SHEET TITLE: **SITE PLAN**

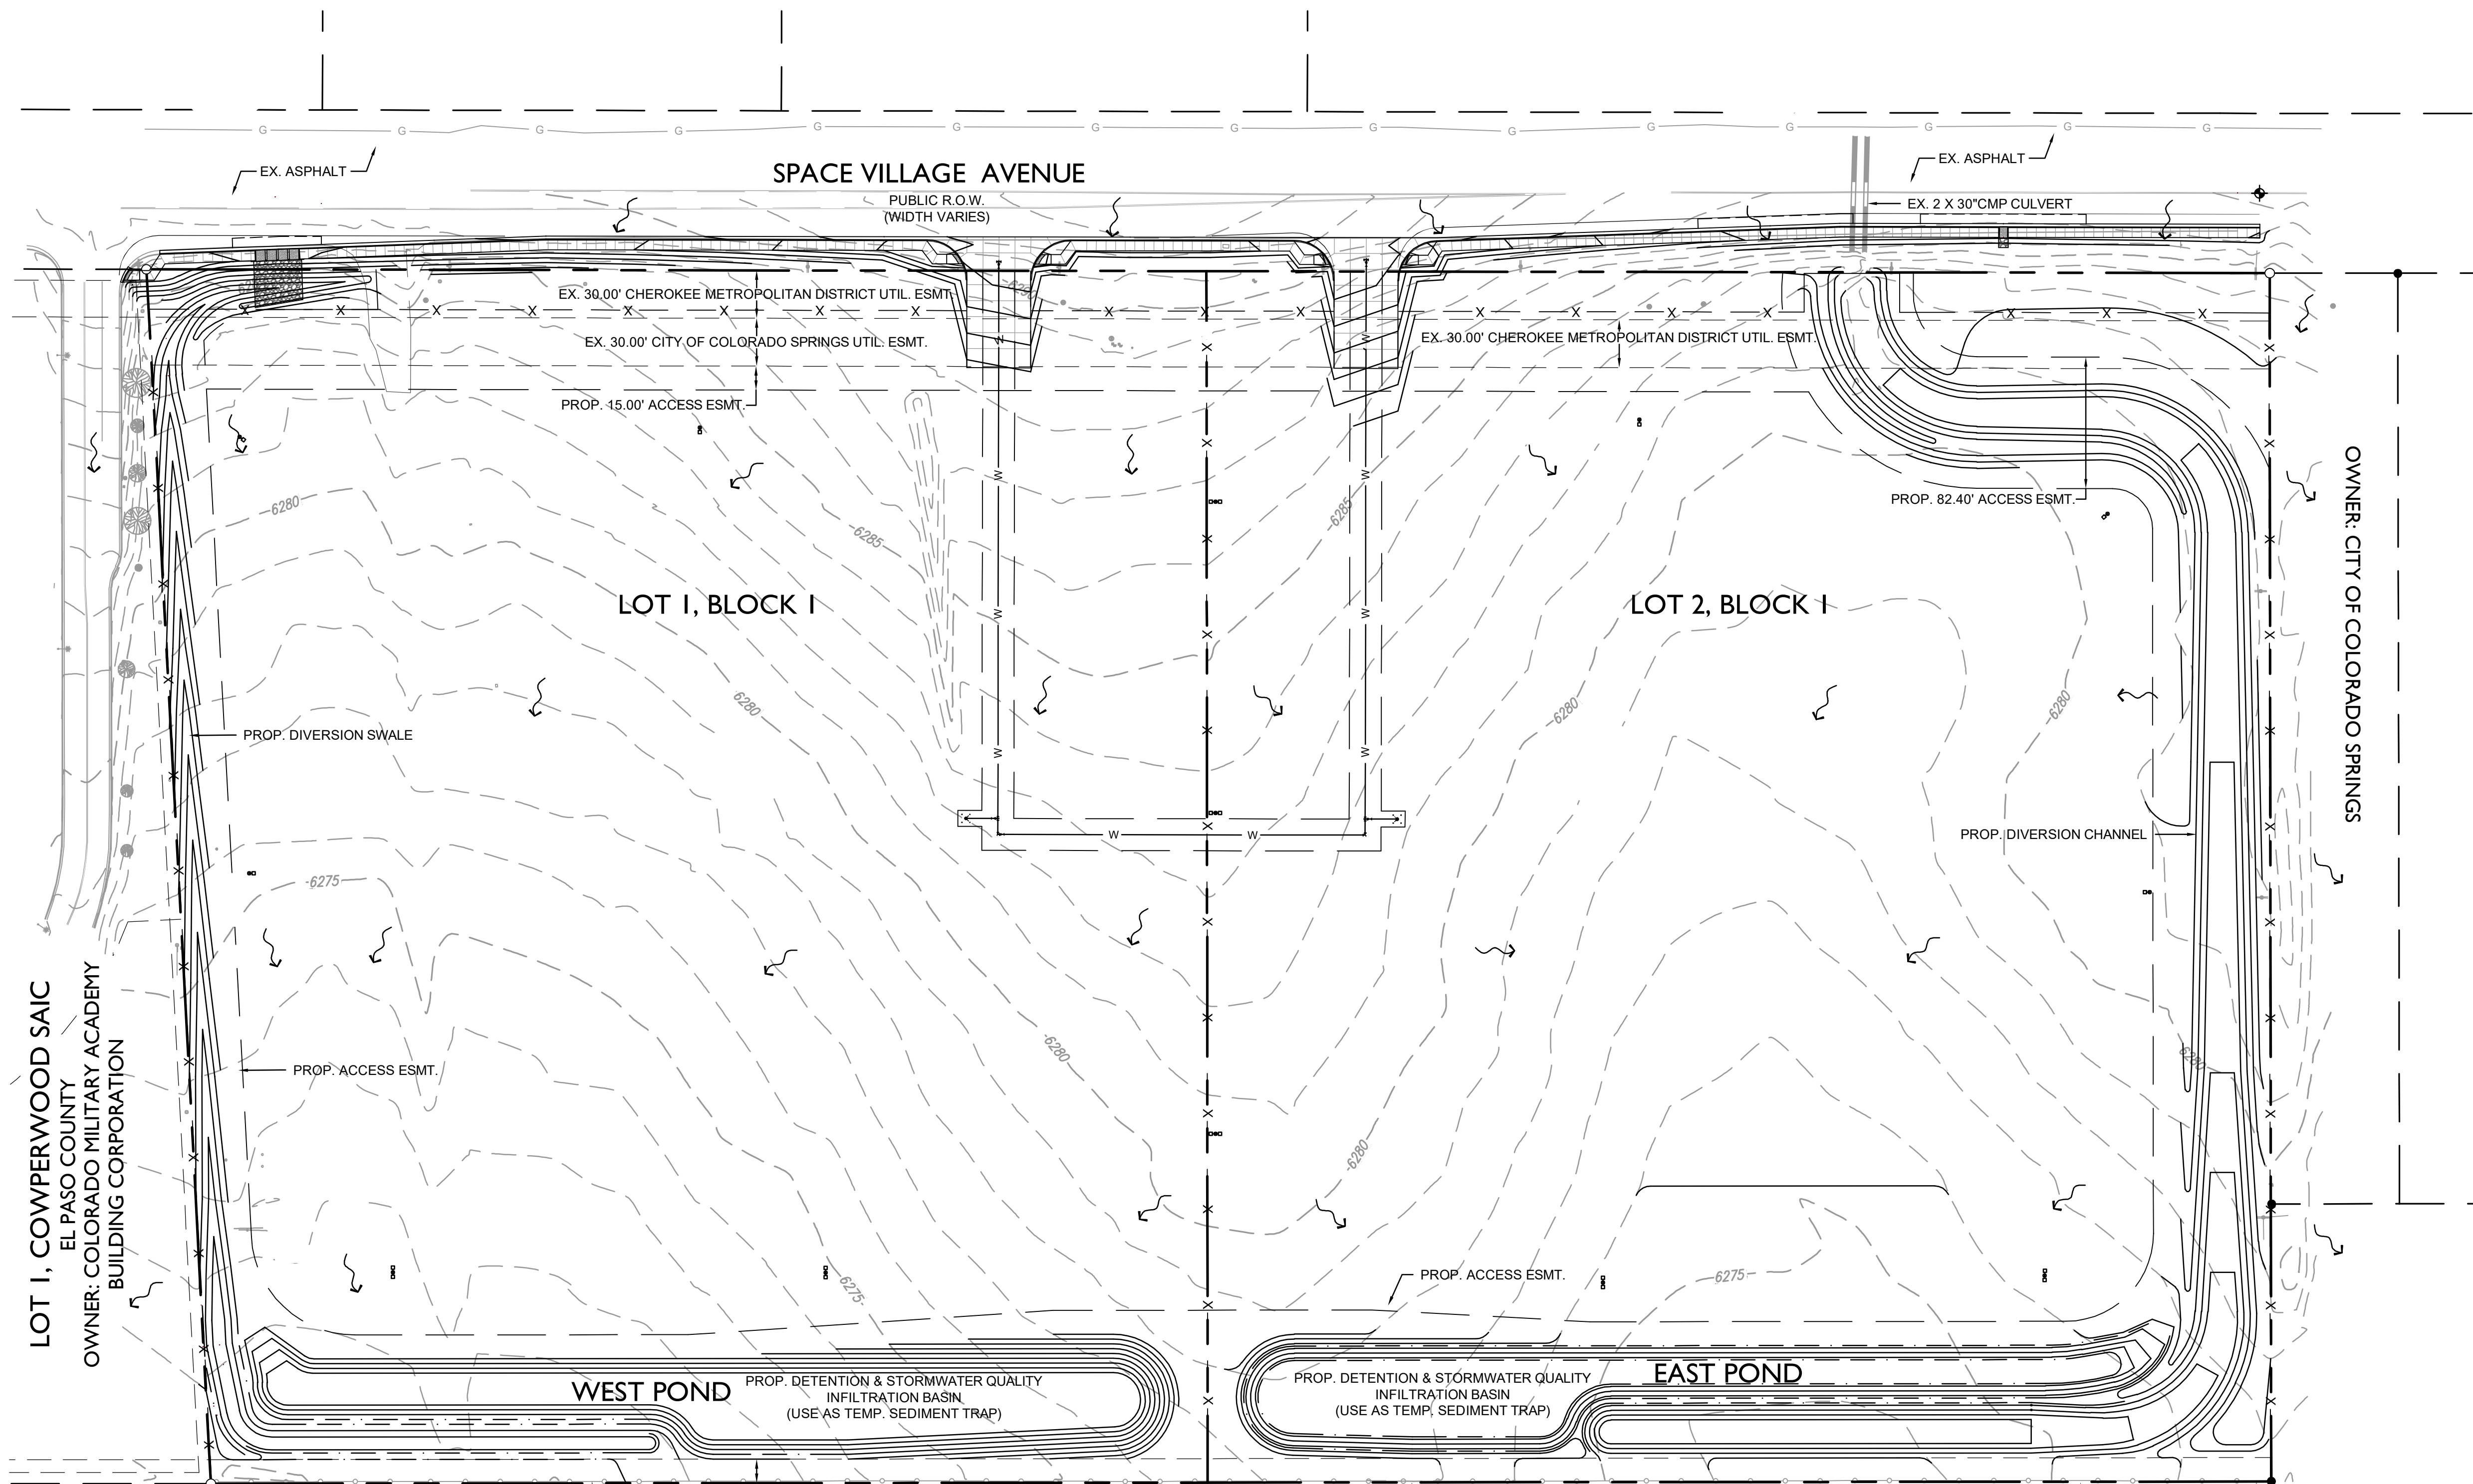
The numbering of the lots is confusing as there are only two distinct lots on the approved Site Development Plan. Please explain or number according to the official legal descriptions which are Lot 1, Block 1, and Lot 2, Block 1 in Space Village Fil No 4. To clarify, please leave the lot lines as they are approved, and indicate on this revised plans which uses are occurring on each lot, similar to the additional site plan you submitted. Please also ensure you are meeting the requirements of the Site Development Plan checklist at the link below:
